Recommendation Report for Planning Permission for Works or Extension to a Dwelling

REF NO: LU/49/22/HH

LOCATION: 27 Clun Road
Wick
Littlehampton
BN17 7DZ

PROPOSAL: Single storey rear extension.

PROPOSED ELEVATIONS

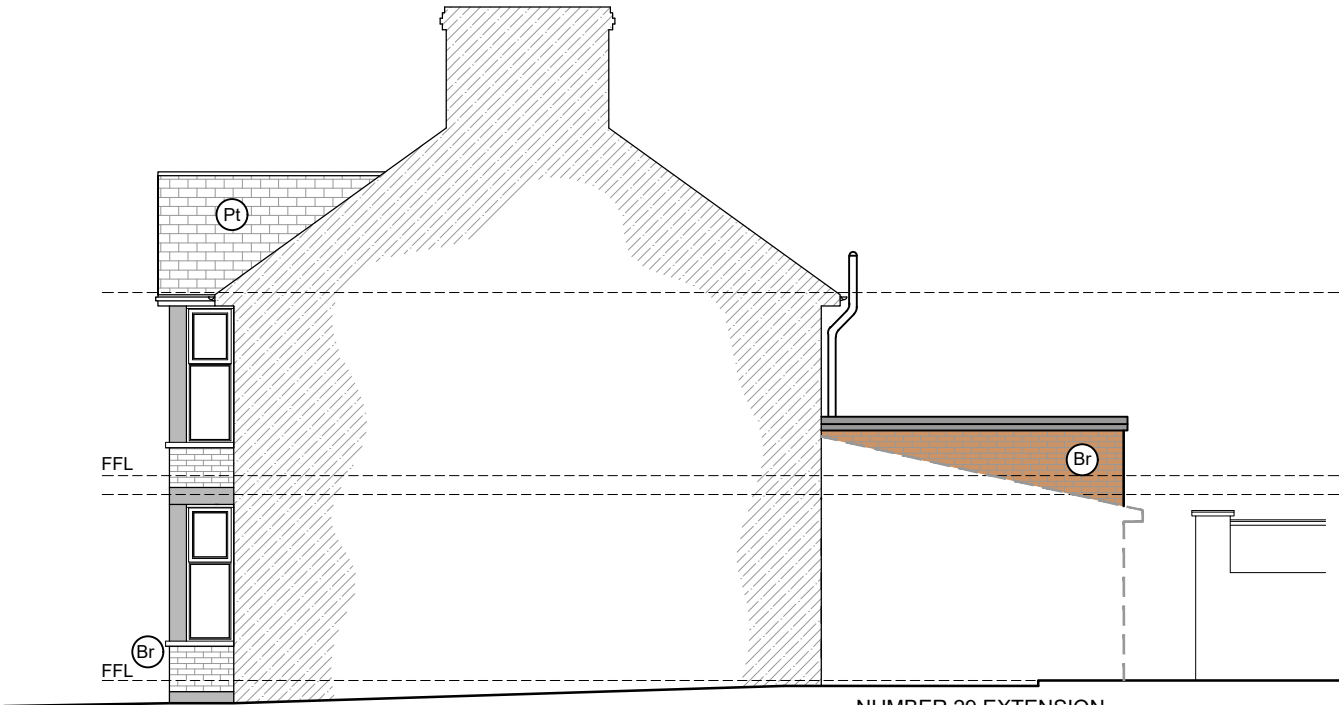
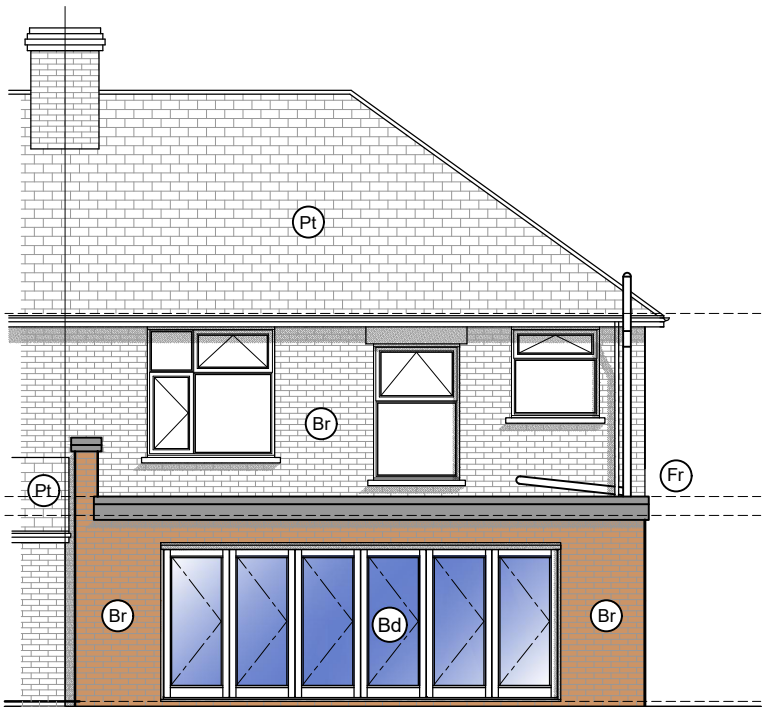
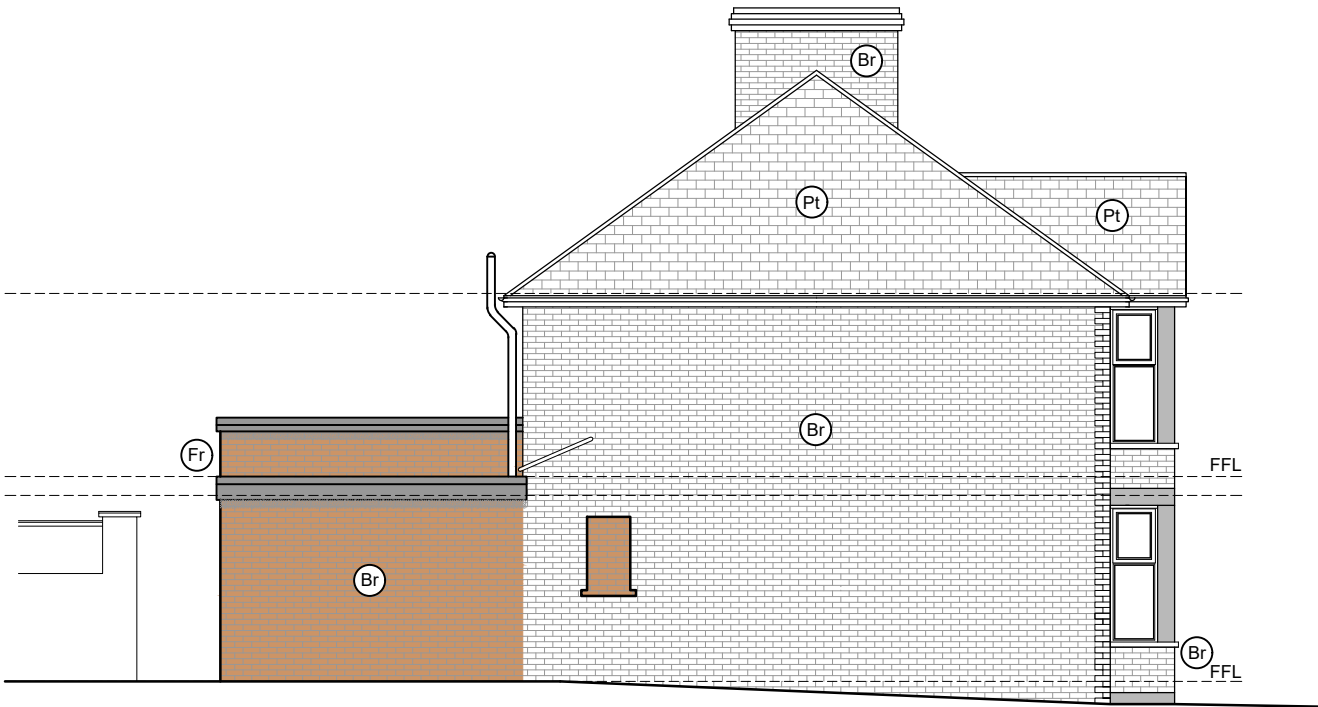
The proposal is a single storey rear extension that measures 4m in depth, approx. 7.52m in width, 3.5m at peak height and 2.7m at eaves height. The proposal features a flat roof design with 2 No. rooflights. The scale is moderate and the proposal is subservient to the host dwelling. The proposal is 4m in depth which is equal to that of the single storey rear extension to the rear of the West neighbour dwelling (No.29 Clun Road). The materials proposed are to match those found on the existing dwelling and as such are appropriate. There is a low wall to the West elevation that sits atop the proposed rear extension. The wall projects approx. 0.8m above the roof of the proposed extension reaching the peak height of 3.5m. This feature would cover the side elevation of No.29s rear extension and is an acceptable feature.

The proposal is to the rear elevation and as such is not visible from the wider street. However, the East site boundary of No.27 Clun Road is met by a public footpath. The single storey rear extension will have slight views from this public footpath as it crests over the top of the boundary treatment wall. The visual impacts here will be infrequent and minimal. Furthermore, the impacts are acceptable as the design of

the extension is sympathetic to the host dwelling and in keeping with the character of the area.

There are a set of rear facing Bi-fold Glass and Aluminium doors to the rear of the extension. These lookout to the rear garden and do not give rise to any adverse impacts by way of overlooking.

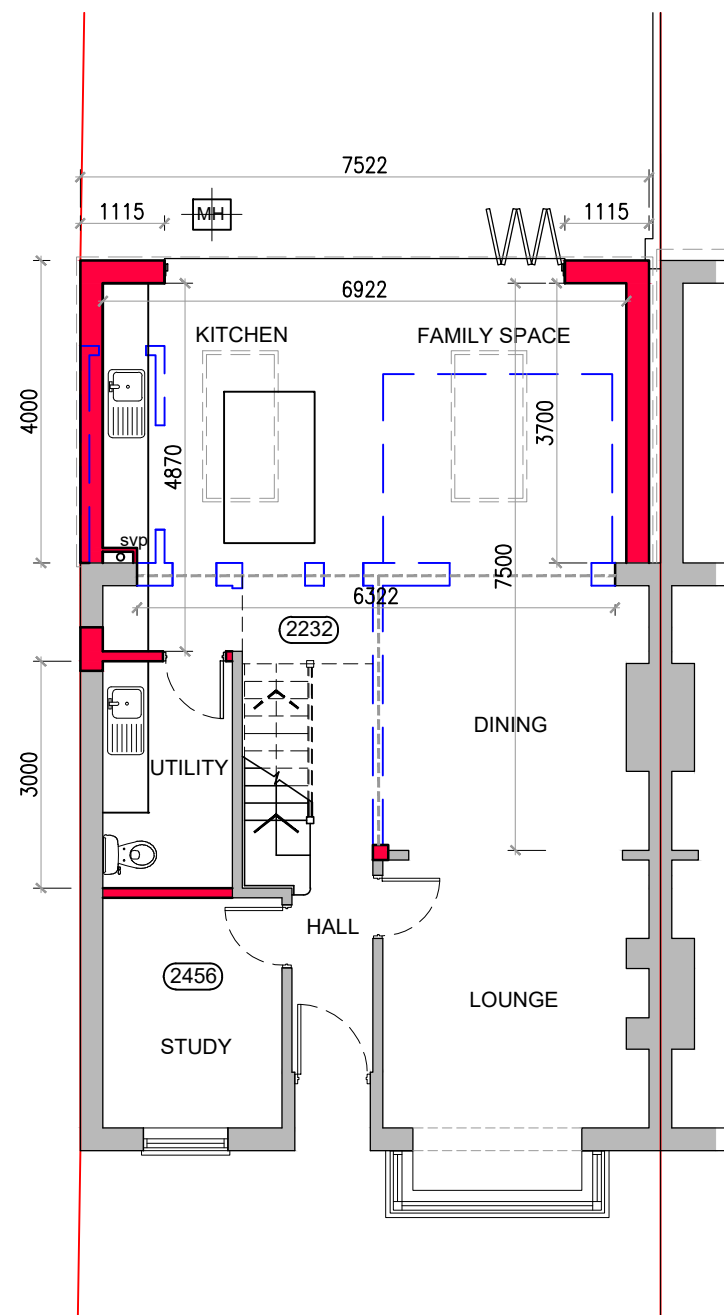
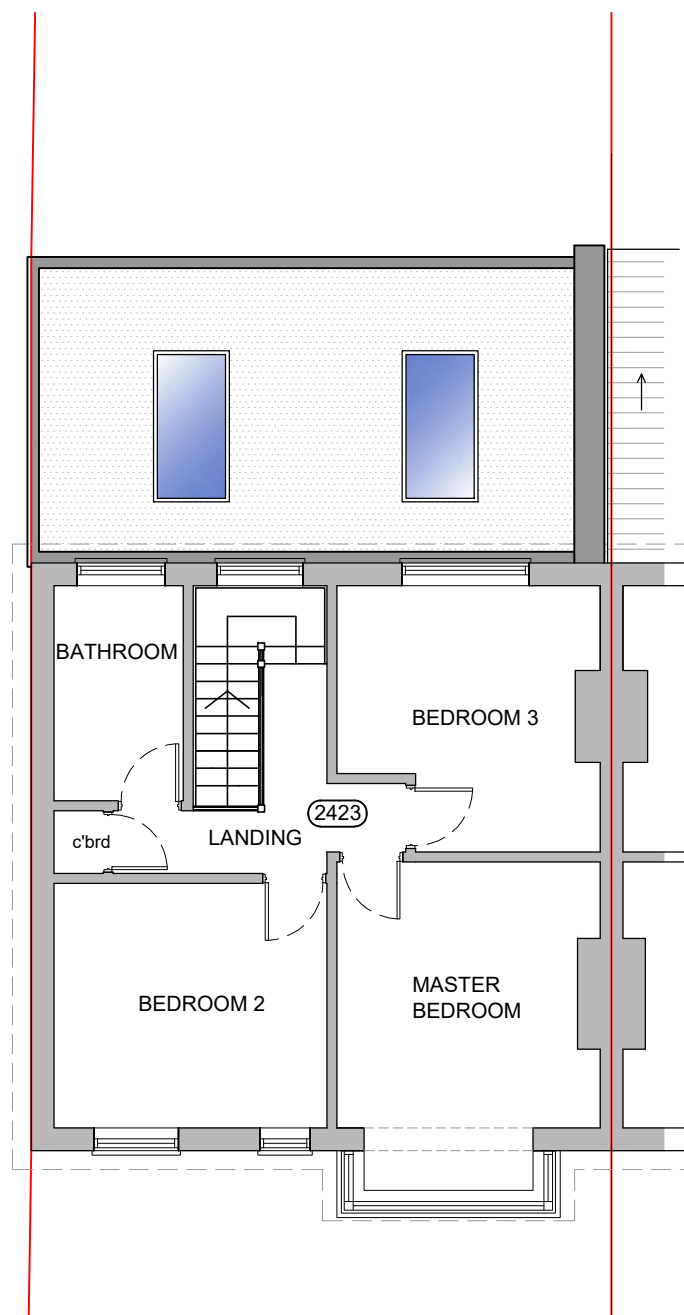
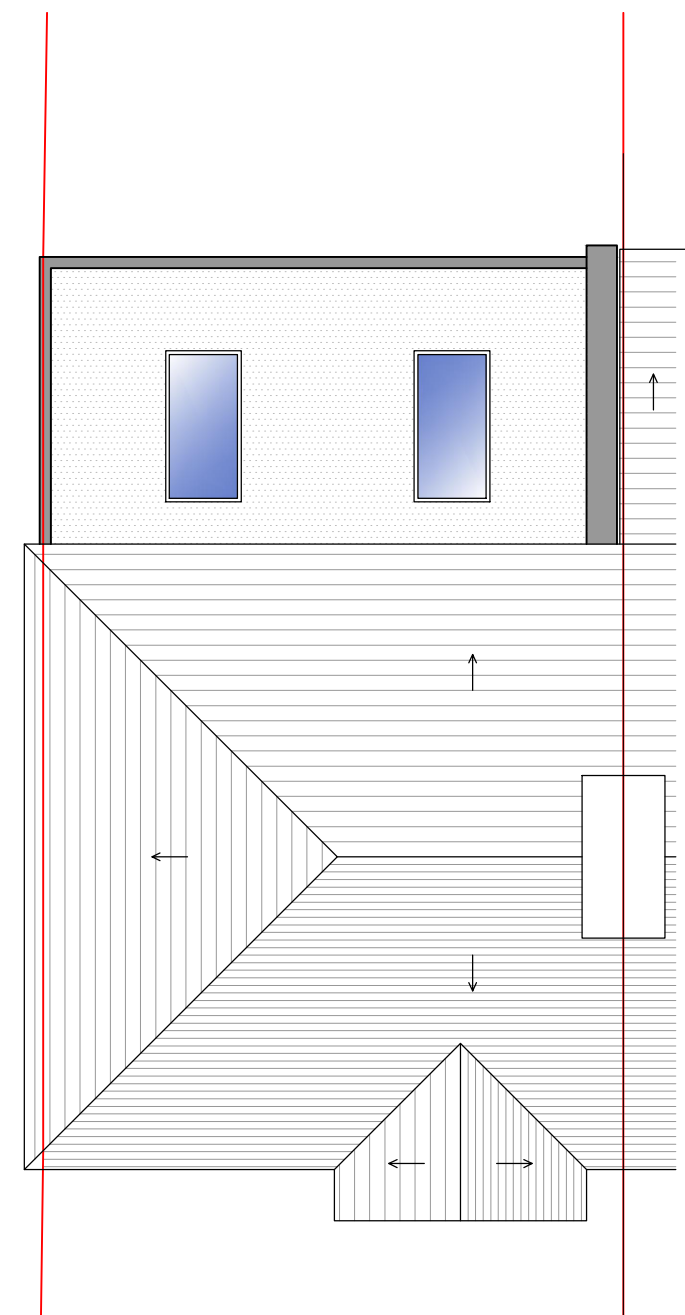
The scale and siting of the rear extension is such that it does not exceed the depth of the neighbour dwelling (No.29 Clun Road). Given that the property is not a direct neighbour to any other dwellings and the scale of the proposal is minimal, no other nearby dwelling are the subject of any potential impacts of overbearing, overshadowing or overlooking. There is no obstruction of 45 degree light accessibility lines or 60 degree sight lines at No.29. Therefore, the proposal does not give rise to any adverse impacts by way of overshadowing or overbearing on the attached neighbour (No.29).
